Recommendation Report for Planning Permission

REF NO: BN/75/19/PL

LOCATION: Land adjacent to Cherry Trees
Lake Lane
Barnham
PO22 0AD

PROPOSAL: 1 No. dwelling & associated works.

SITE PLAN  
LOCATION PLAN  
FENCES/GATES  
JULY 2019  
DRAWING 1  
SCALE AS SHOWN (A3)

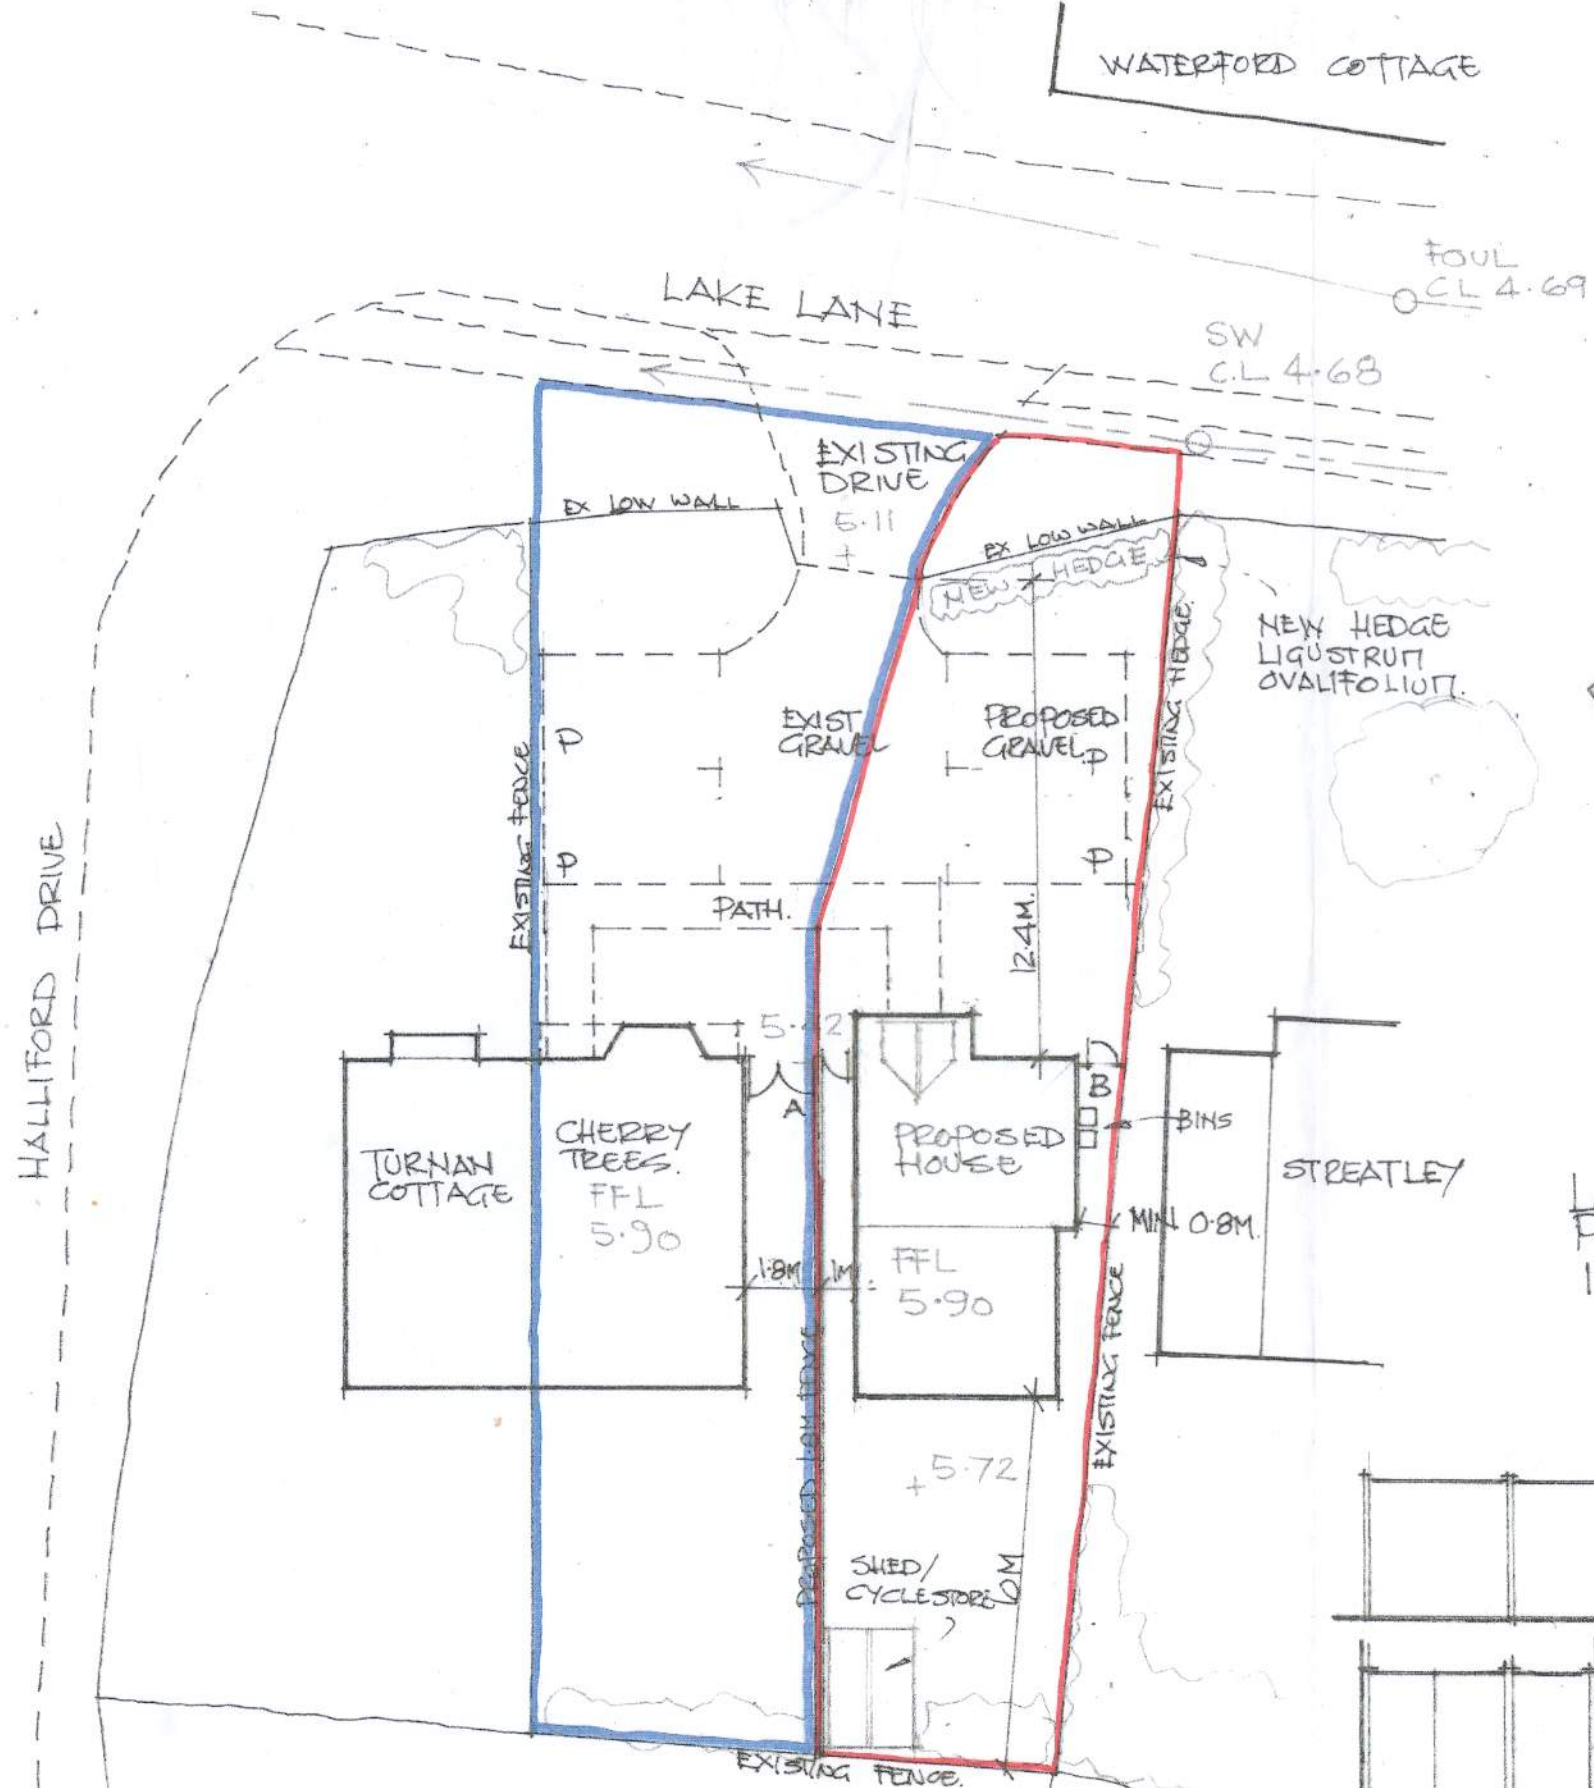
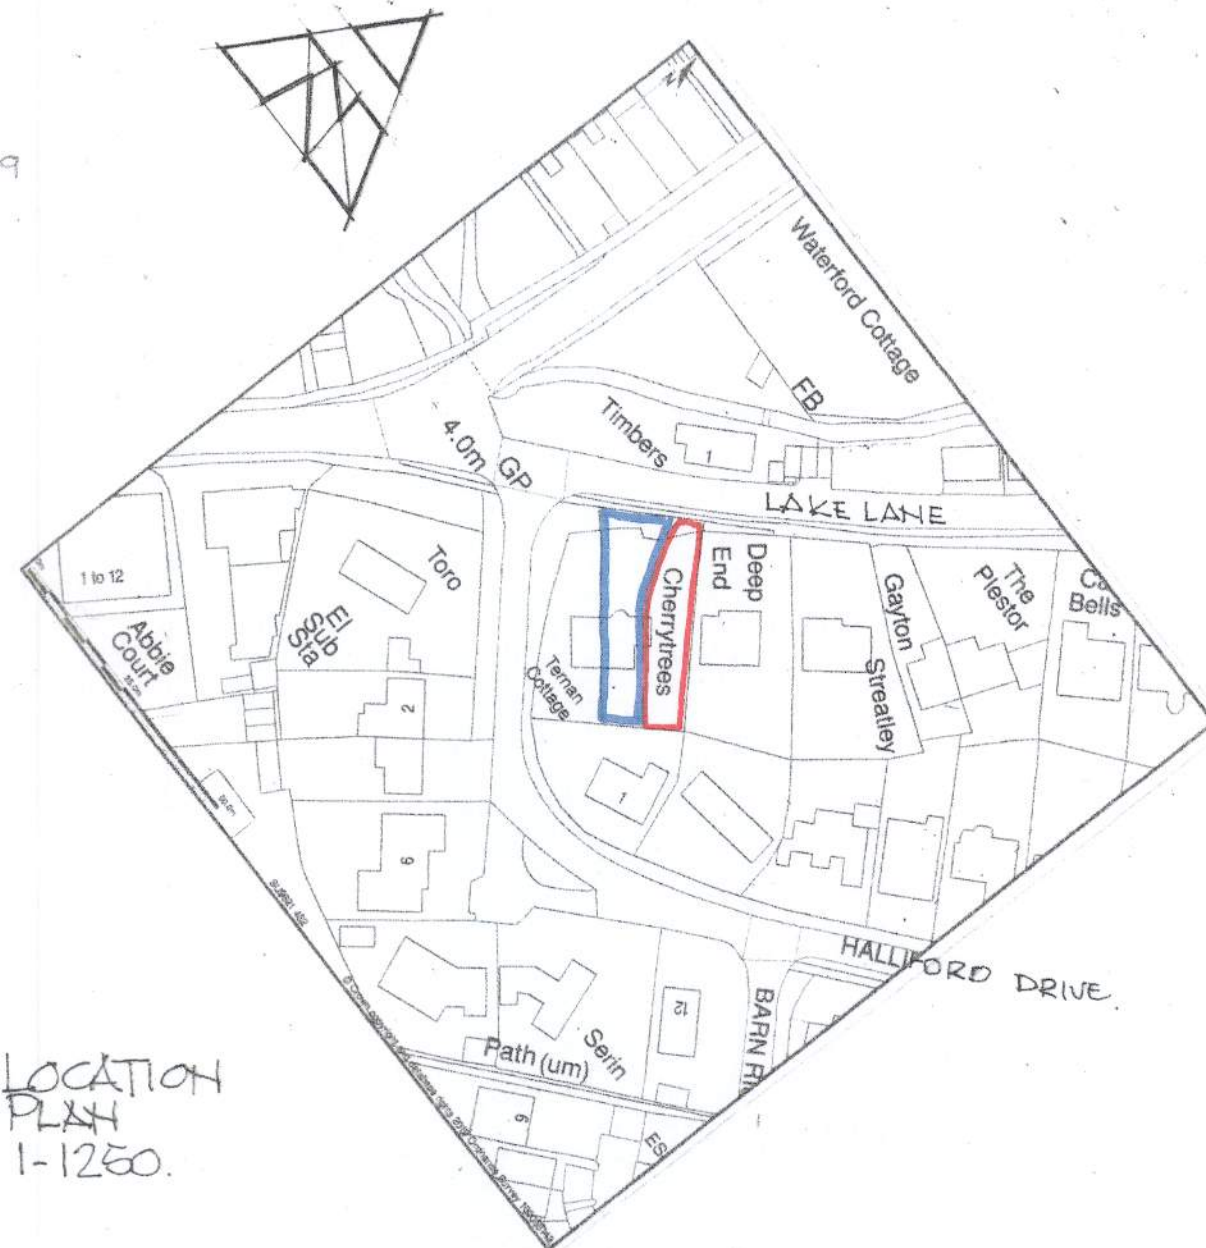
An amended plan was received on 14th January 2020 which confirms that existing trees on site will be kept along with clarification of the existing boundary treatments and vegetation.

The size of the site is small but there are other similarly sized sites in the surrounding area. The dwelling would be positioned in an existing garden area between Cherry Trees and Deep End. A distance of 0.8m is kept to the north-eastern boundary and a distance of 1m is kept to the south-eastern boundary which allows space for bin and bike storage at rear. This space is minimal but again not uncommon in the nearby area. From a streetscene perspective the proposed would have a similar width, height and roof form as some other nearby dwellings. As a result the development would be in keeping with the general

PLANS
ELEVATIONS
STREET SCENE
JULY 2019
DRAWING 2.
SCALES AS SHOWN (A3)

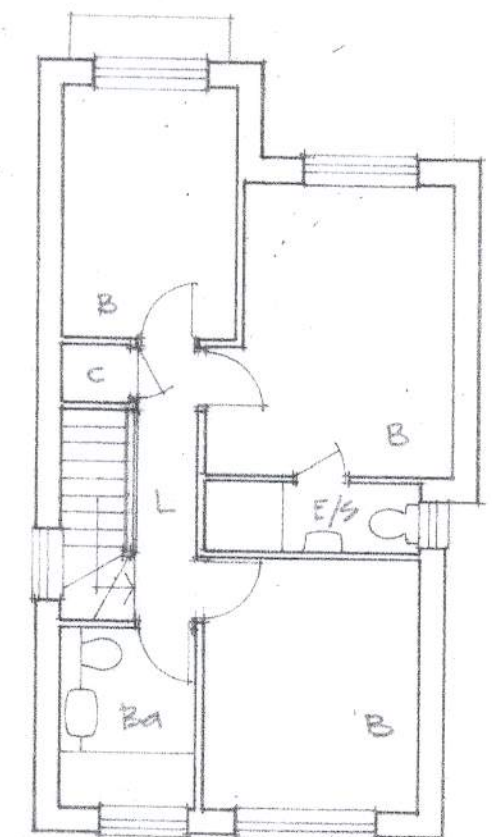
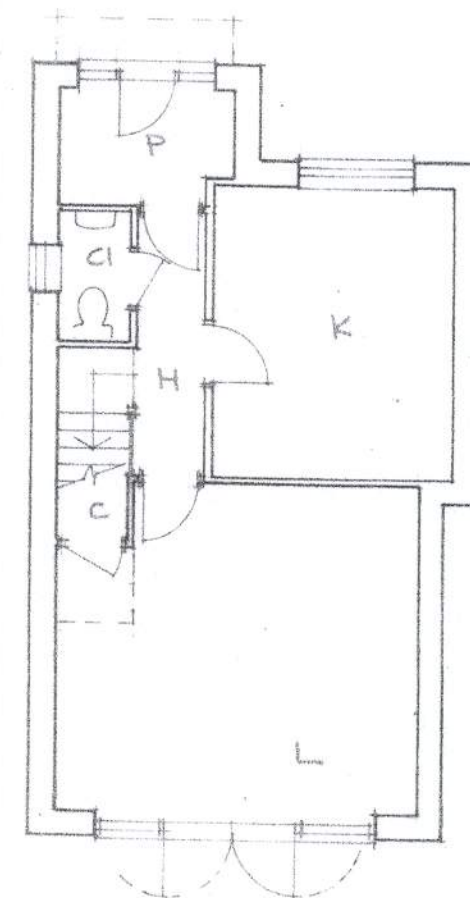
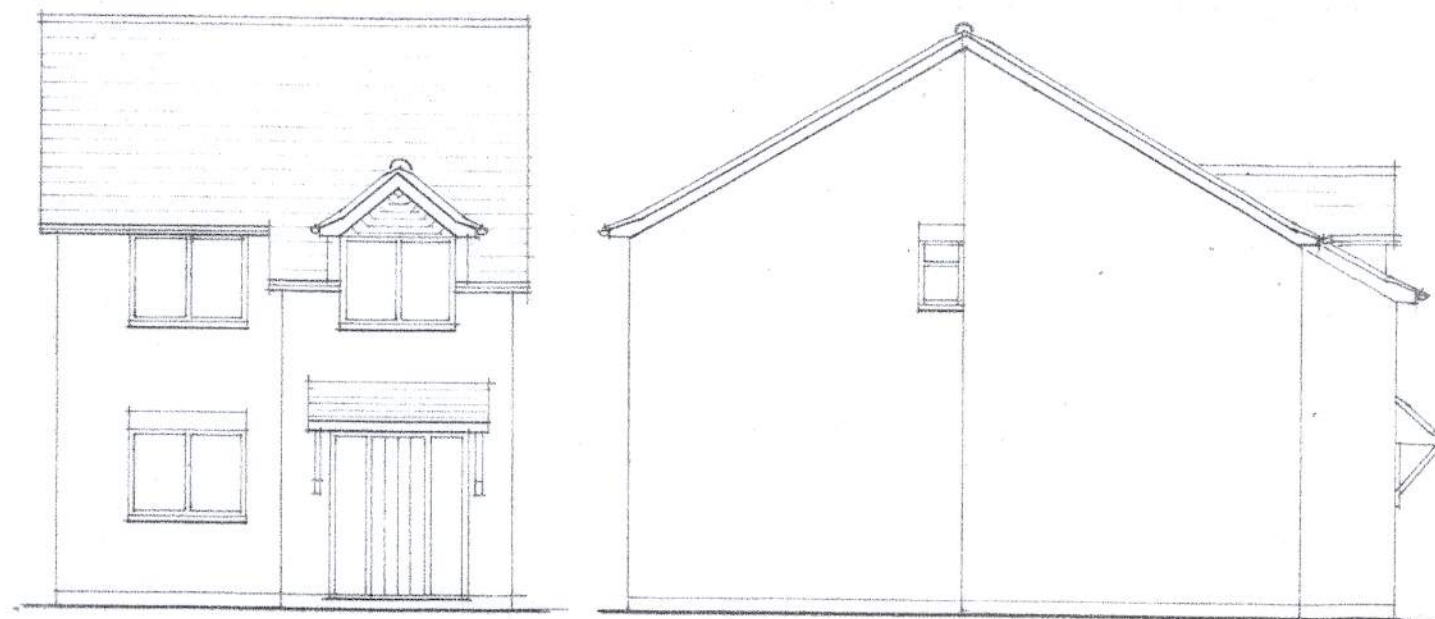
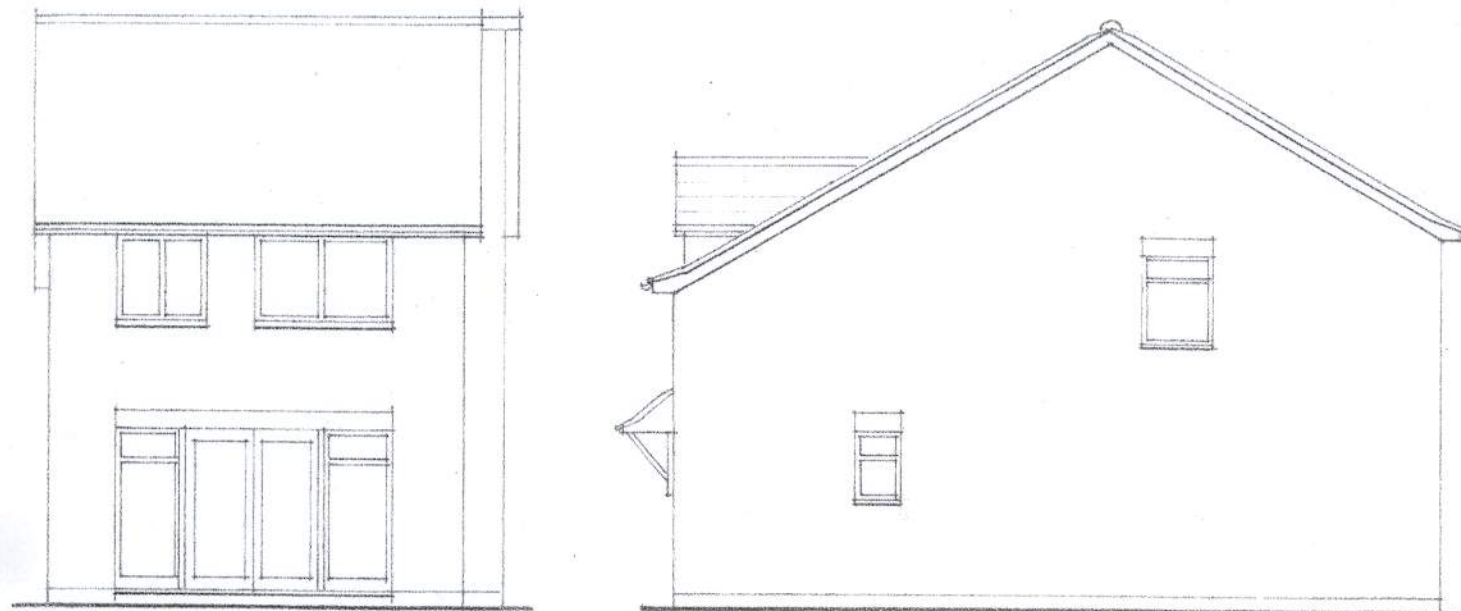
The front facing dormer window in the proposed dwelling would face onto Lake Lane and the dwelling opposite, 'Timbers', where privacy would not be significantly affected due to the distance involved. Two side facing windows are proposed for the south-eastern elevation, one would be for a 1st floor landing area and the other would be for a ground floor bathroom. This ground floor bathroom window would be obscure glazed by condition if approval was granted and the landing area is not a habitable room thereby limiting any potential overlooking of Cherry Trees. One window is proposed for the north-eastern elevation and this would be for a bathroom window which would also be obscure glazed by condition, if permission was granted.

In terms of any other overlooking the proposal would be approx. 10m from its nearest neighbour to the rear No. 1 'The Heathers'. This distance is not sufficient to prevent overlooking even with the existing boundary conditions at rear. A distance of approx. 21m is encouraged between proposed rear elevations and neighbours at the rear in the draft Arun Design Guide.

- 1 The dwelling by reason of its design and proximity to the dwelling to the rear would cause demonstrable harm by reason of direct overlooking of neighbouring properties to the rear to the detriment of the amenities of the occupants of this property in conflict with policy D DM1 of the Arun Local Plan.
